CHARLOTTE-MECKLENBURG PLANNING COMMISSION
INTER-OFFICE COMMUNICATION

SUBJECT: Administrative approval for petition #89-72 by Southern Realty Dev. Corp. Tax Parcel #082-169-01

Project: PLAZA MATHESON CENTER
Sheet Title: REZONING PLAN (MODIFIED)

SITE PLAN

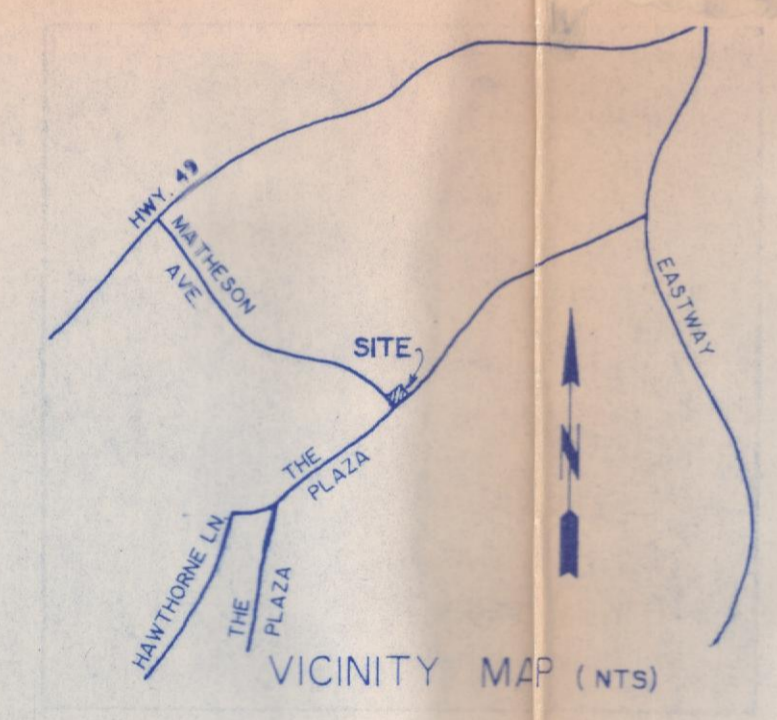
Attached is a revised plan for the above mentioned petition. The plan has been revised to eliminate a retaining wall at the rear of the site. A preliminary grading plan has been done and the need for retaining was eliminated. The wall has been replaced with a two to one slope. The screening at the rear has been supplemented with an additional row of shrubs.
